August 24, 2022

Project Name / File No.: White Barn Dental (Permit #: PA22-029)
Applicant: Titanium Office, LLC
Project Description: Administrative Review – Site Plan
Site Address: 8813 Soper Hill Rd, Marysville
Review: Applicant’s Response to (1st) Review

This letter serves as the Applicant’s formal response to the 1st review comments received from the City of Marysville on August 5, 2022 to our recent application materials submitted to the city on July 7, 2022. To ensure that each of the comments have been responded to, we have incorporated each of the City’s comments along with the Applicant’s response to each below. The responses below are to inform you that we have addressed each of the City’s comments so the review of the application may continue.

Sheet  
**A1.1**

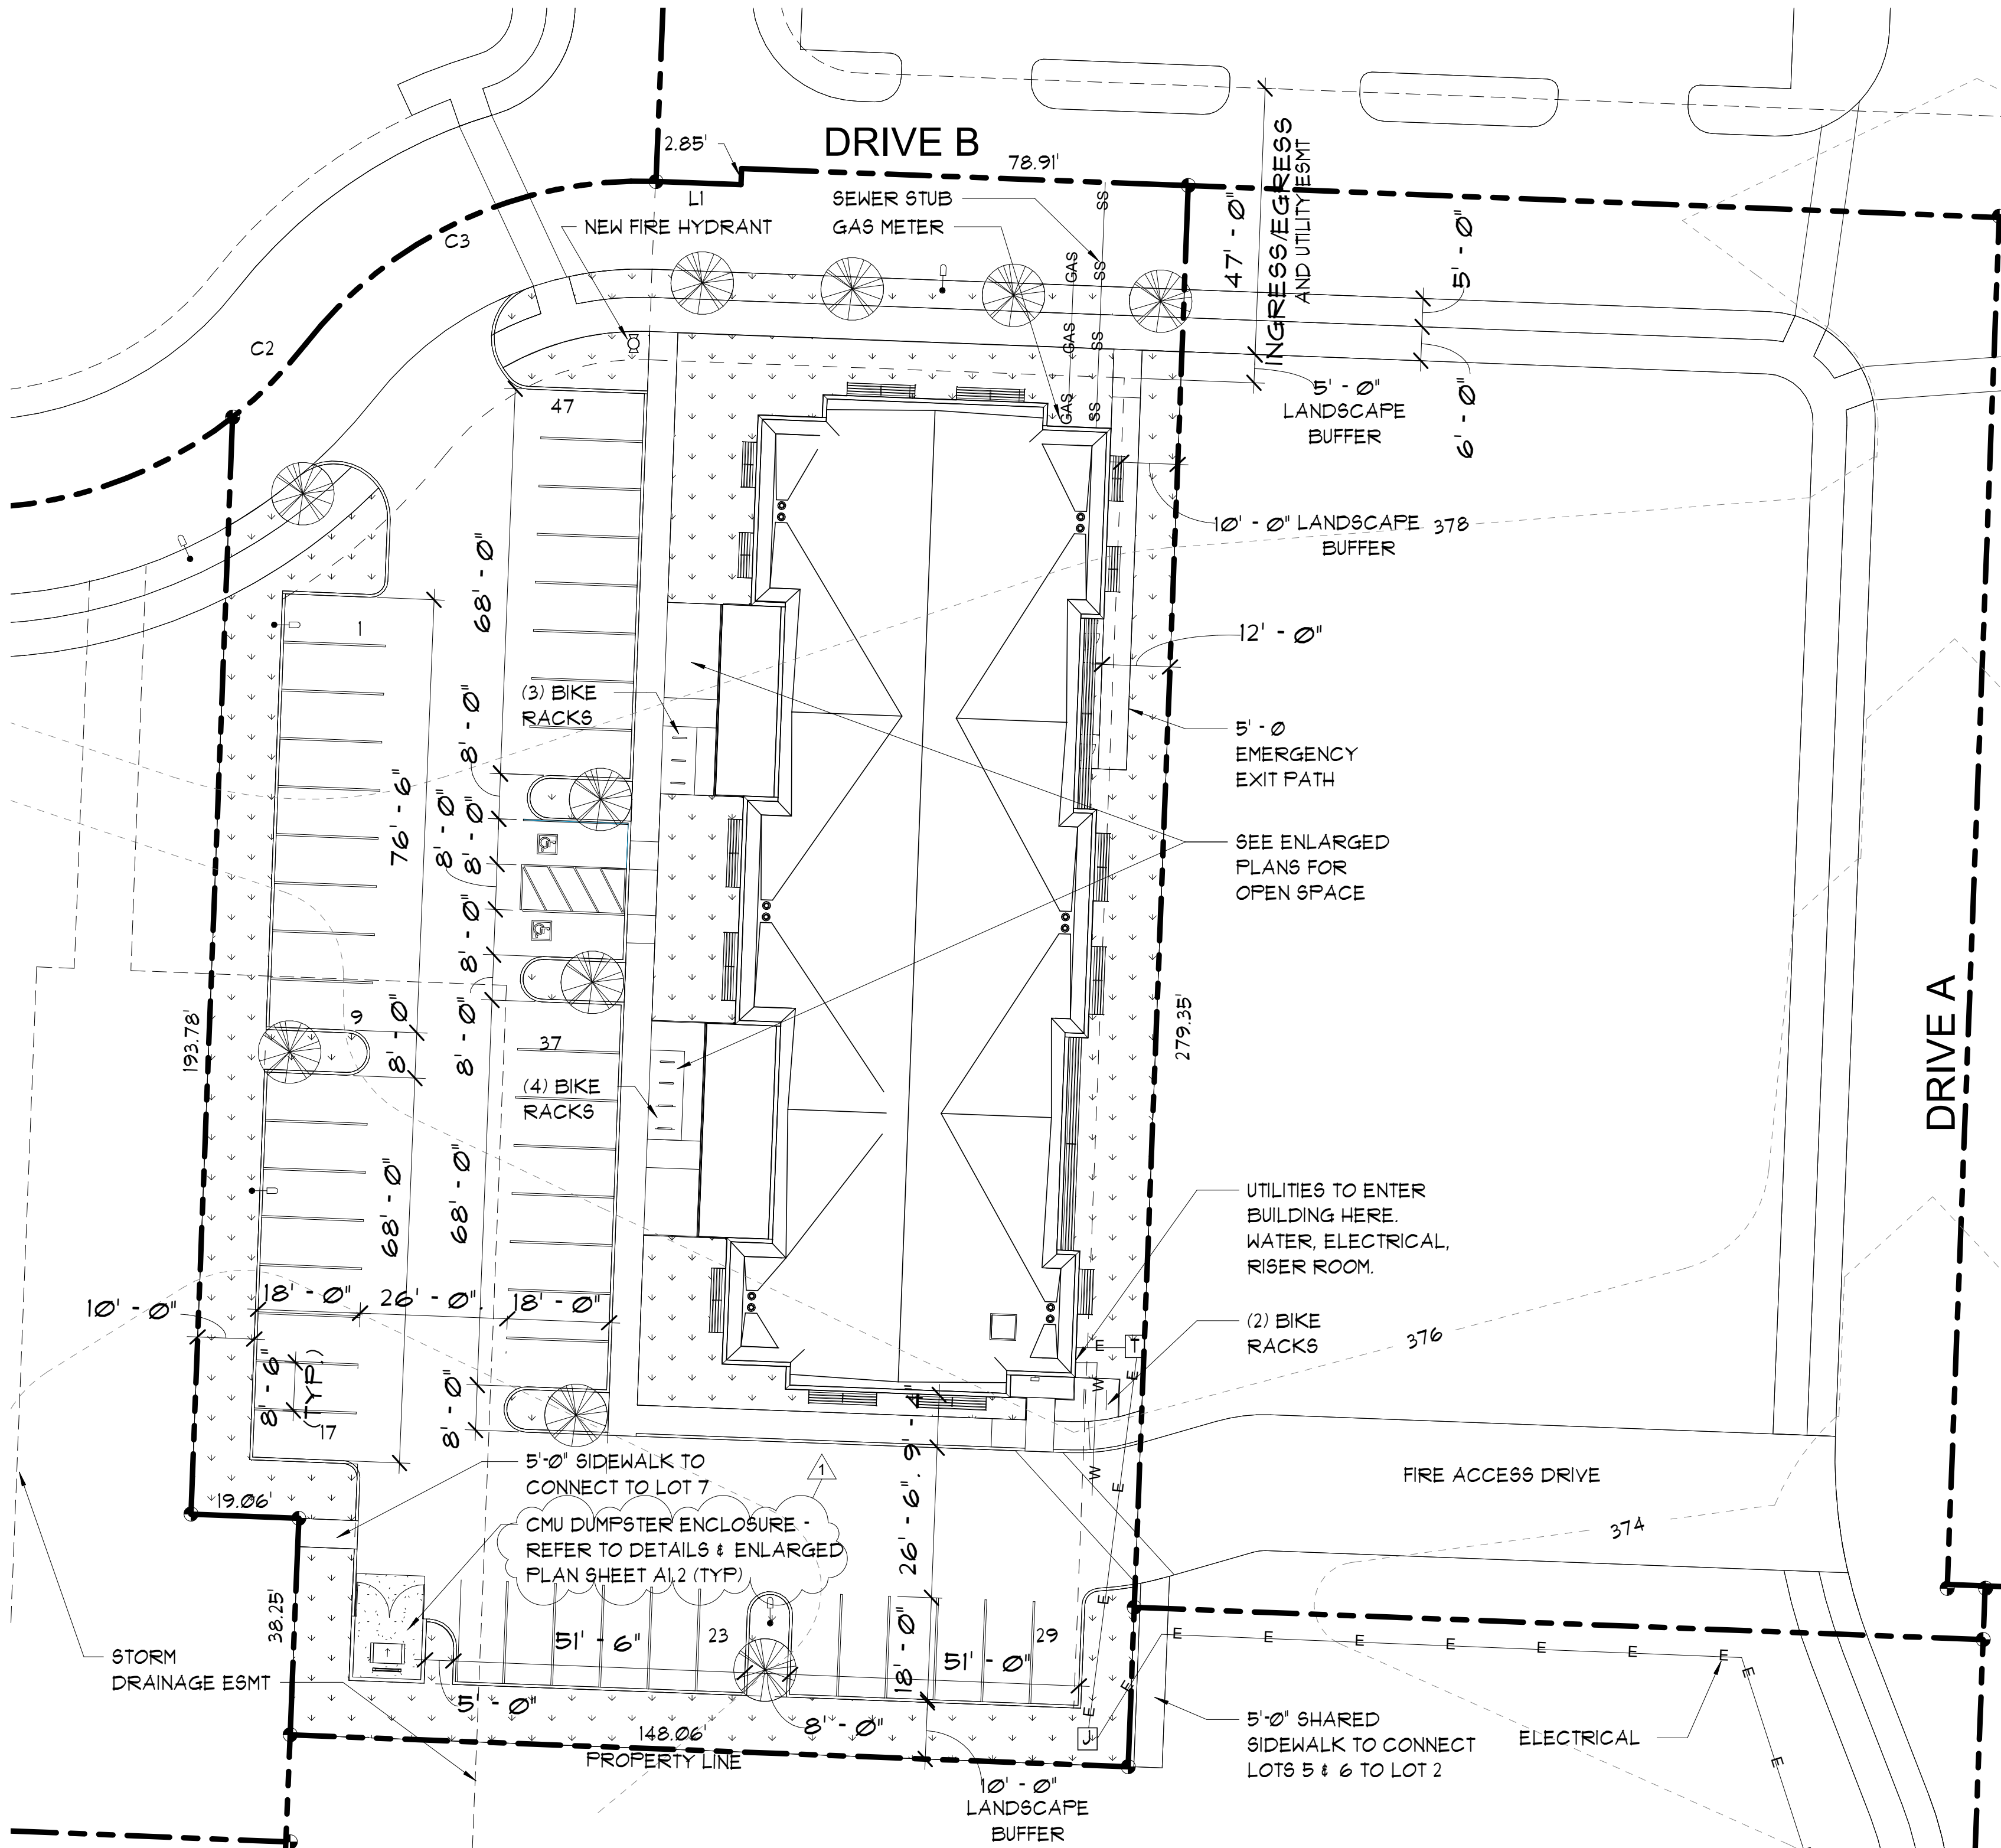
3. Based on the Commercial Business (CB-WR) zoning within the ESWR, the maximum impervious surface allowed is 85% of the lot; this figure was not demonstrated in the application materials. Revise site plan to show this calculation.

Applicant's Response: Site plan sheet A 1.1 has been updated to show impervious surface calculations and coordinated to match Civil Drawings

**13 DUMPSTER ENCLOSURE**  
3/4" = 1'-0"

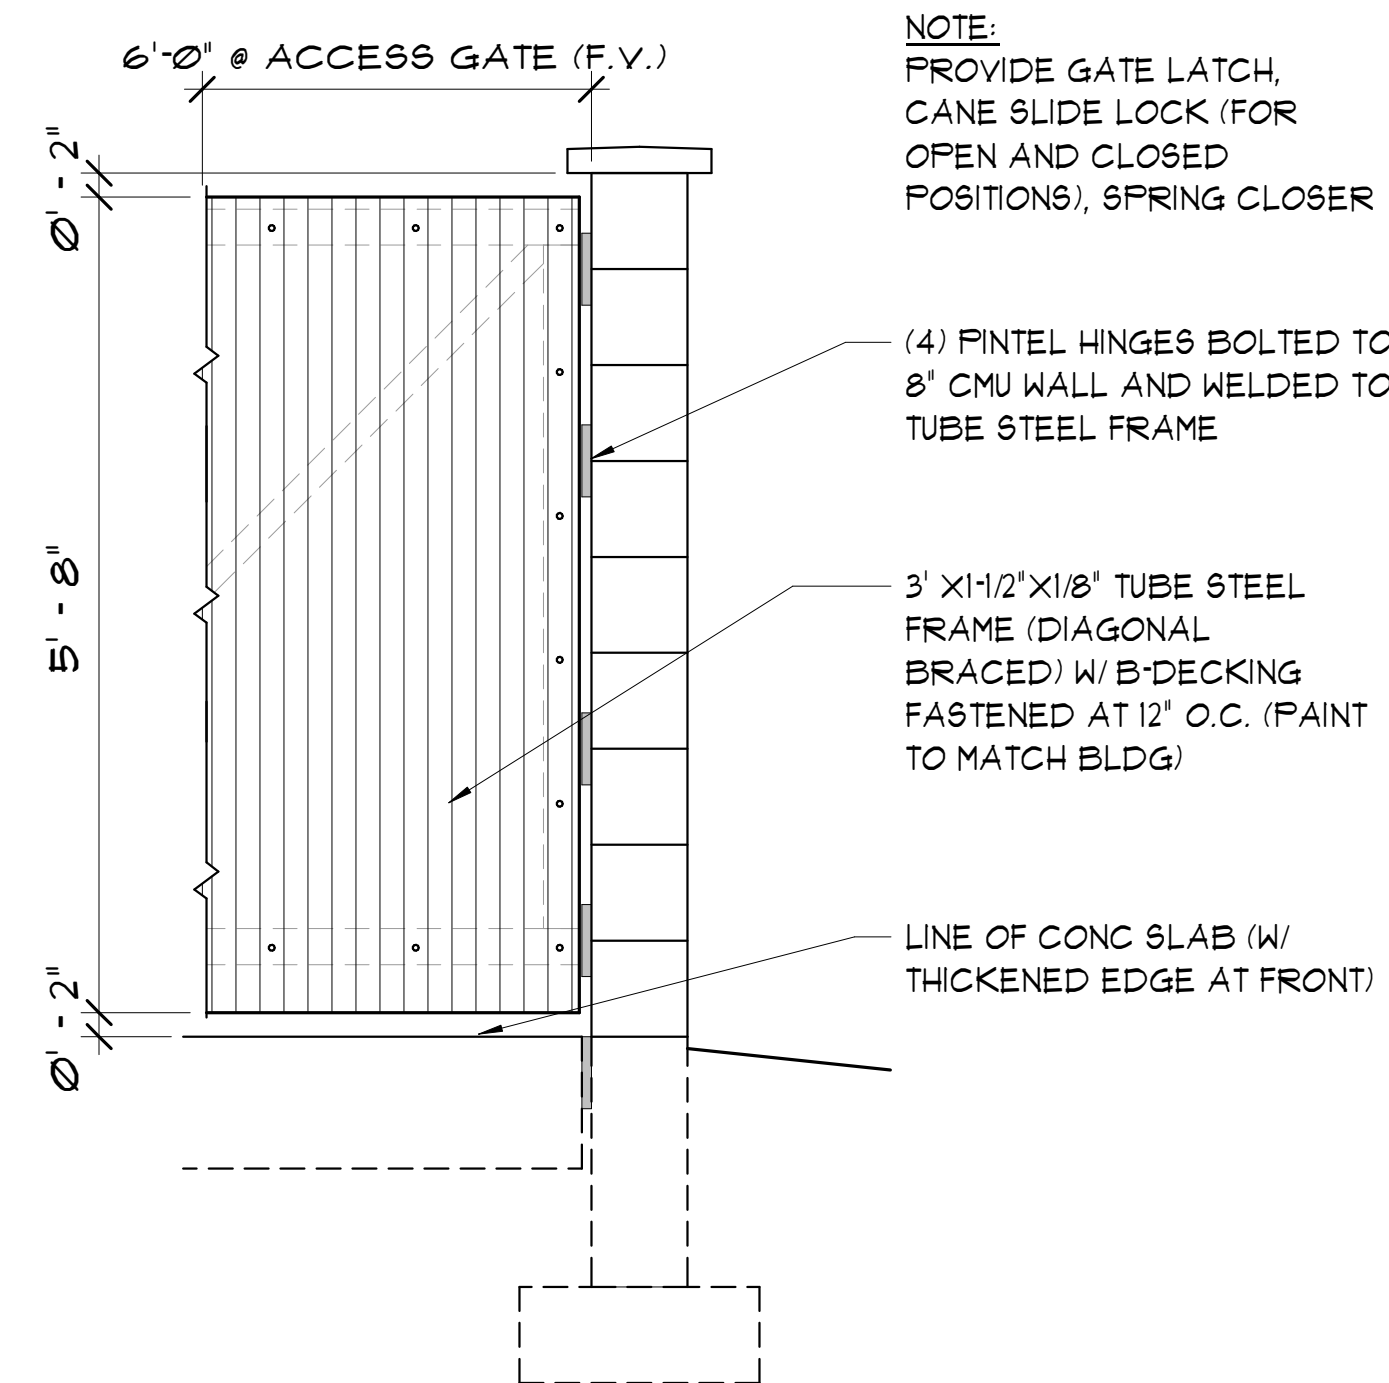
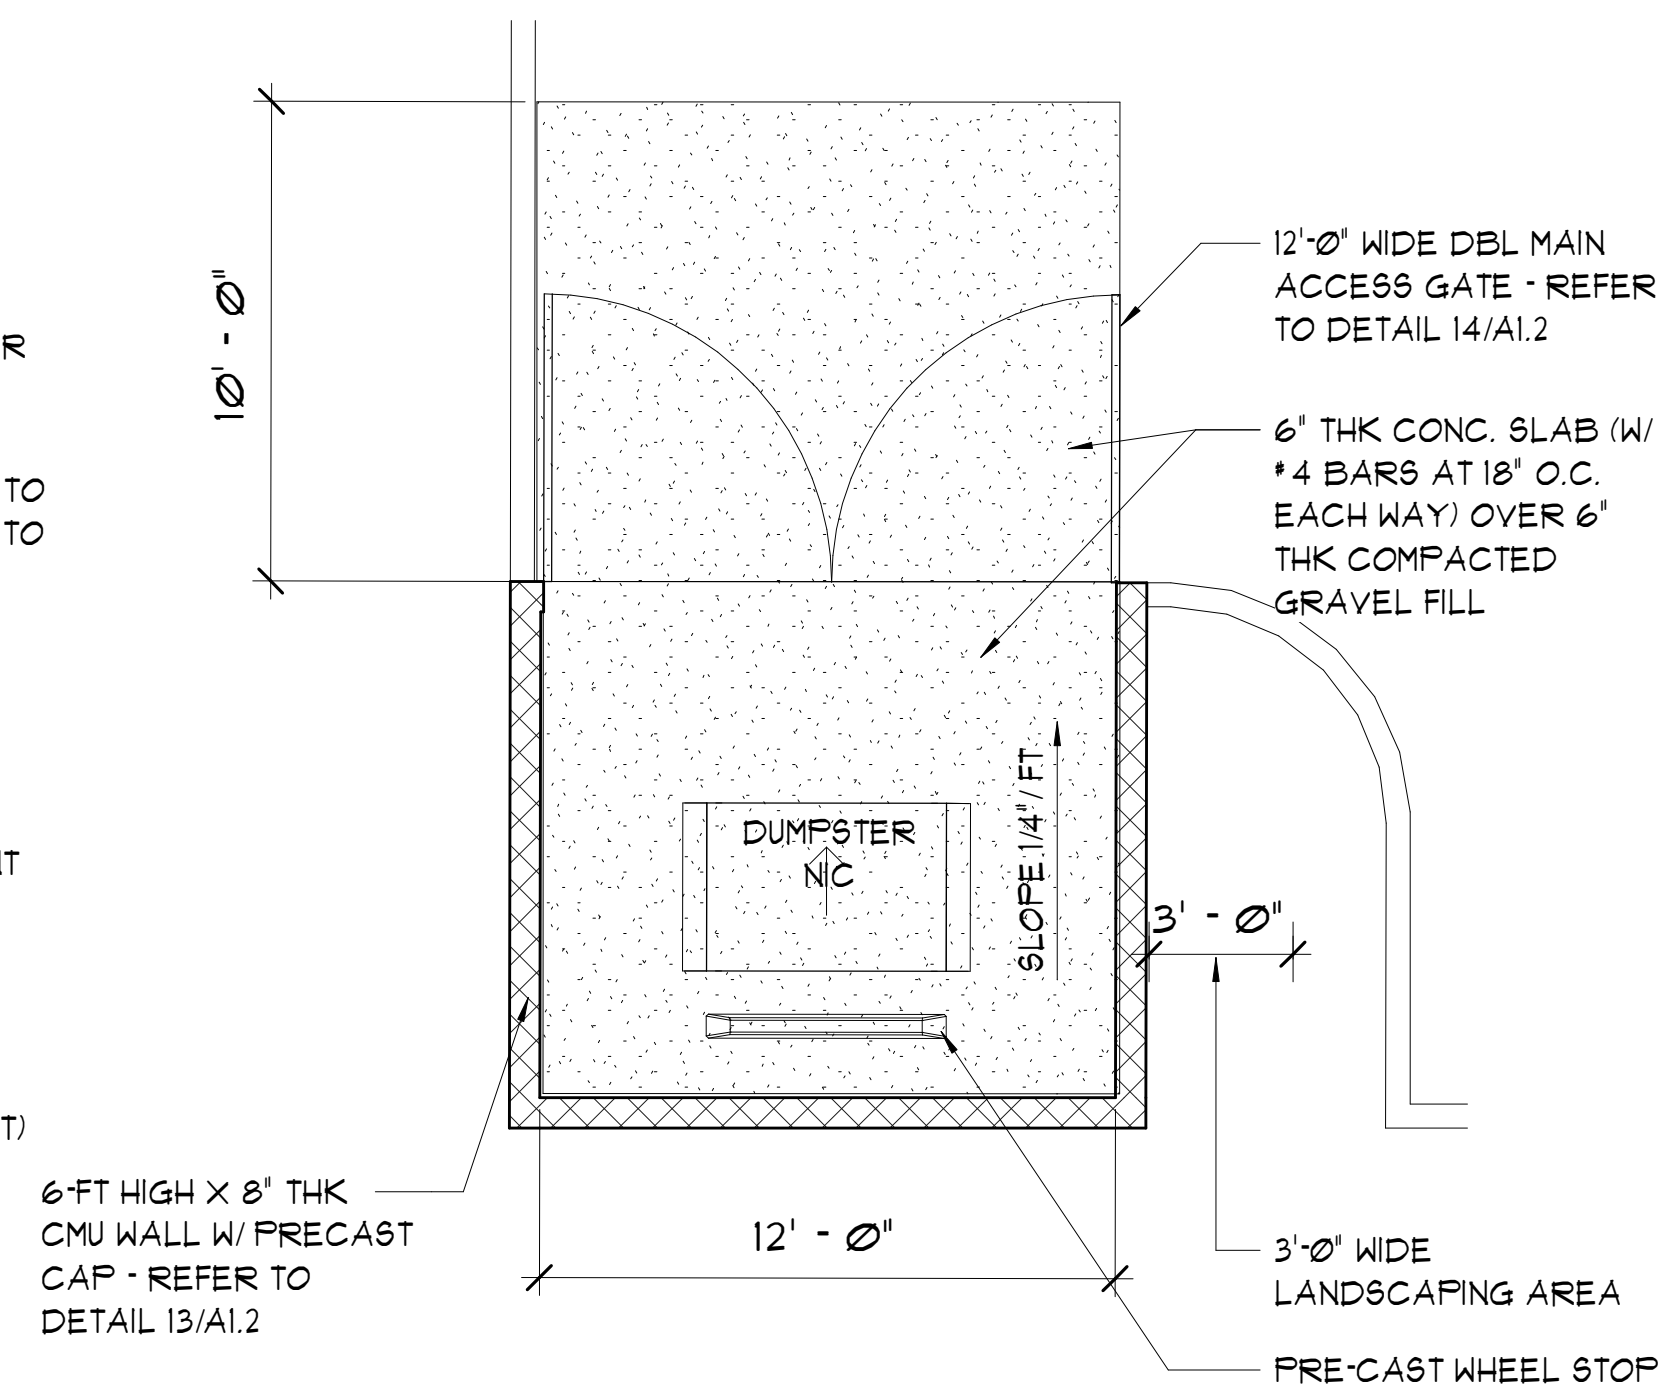
6. Per ESWR F.2.4, trash enclosures are to be fenced with a 6 ft. concrete block or brick fence. This specification was not included in the site plan or landscaping plan—please confirm that the proposed enclosure would meet this requirement.

Applicant's Response: The trash enclosure was designed to be constructed out of CMU block and screening on the access gate. These details can be found on sheet A1.2, details #13-16. I have updated the note on the site plan, sheet A1.1, to be clearer that the trash enclosure is constructed of CMU blocks. Landscaping plan has not been updated to reflect this requirement as the builder will utilize either the civil plans and/or the approved building plans to build this trash enclosure to.
